Application No: FP/113/21/HH
Site Address: 14 Davenport Road Felpham PO22 7JR
Description of works: Hip to gable loft conversion with juliet balcony, alterations to fenestration/openings and external facade.

Thank you for your internet representation made on 4th June 2021 which has been recorded as an objection with the comments as follows:

Dwg No. 21009-P-107-D

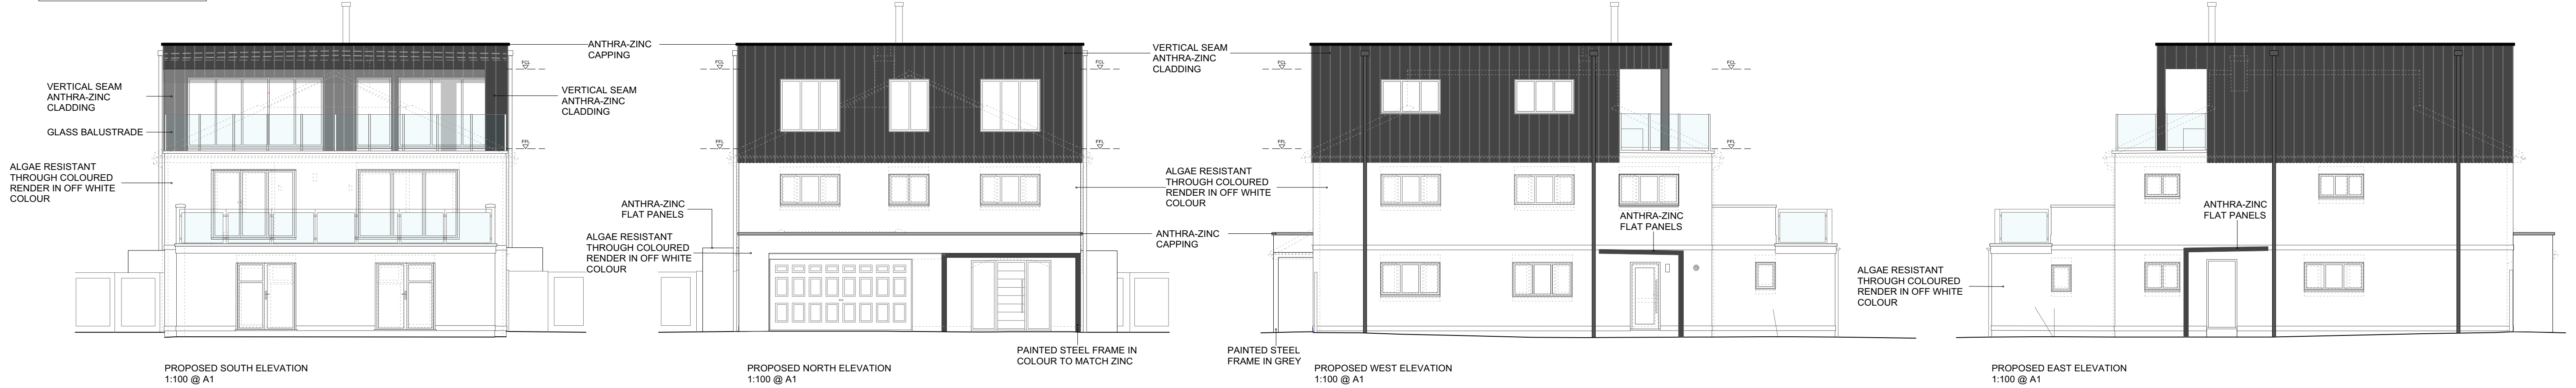
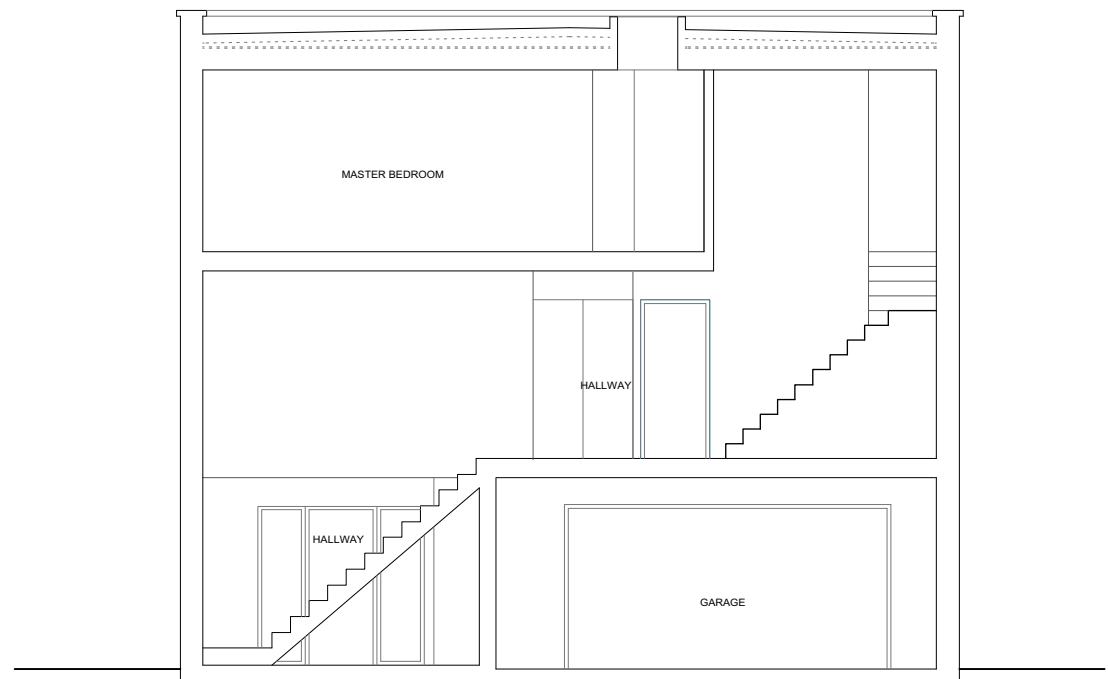
The house is in our direct eyeline to the sea and the imposing box like structure will interrupt our view and is also strongly out of keeping with other houses in the immediate vicinity. The dark nature of the cladding adds to this visual impairment. In addition, the planning application has not been posted for all to view and access as is normally the case with the yellow notices.
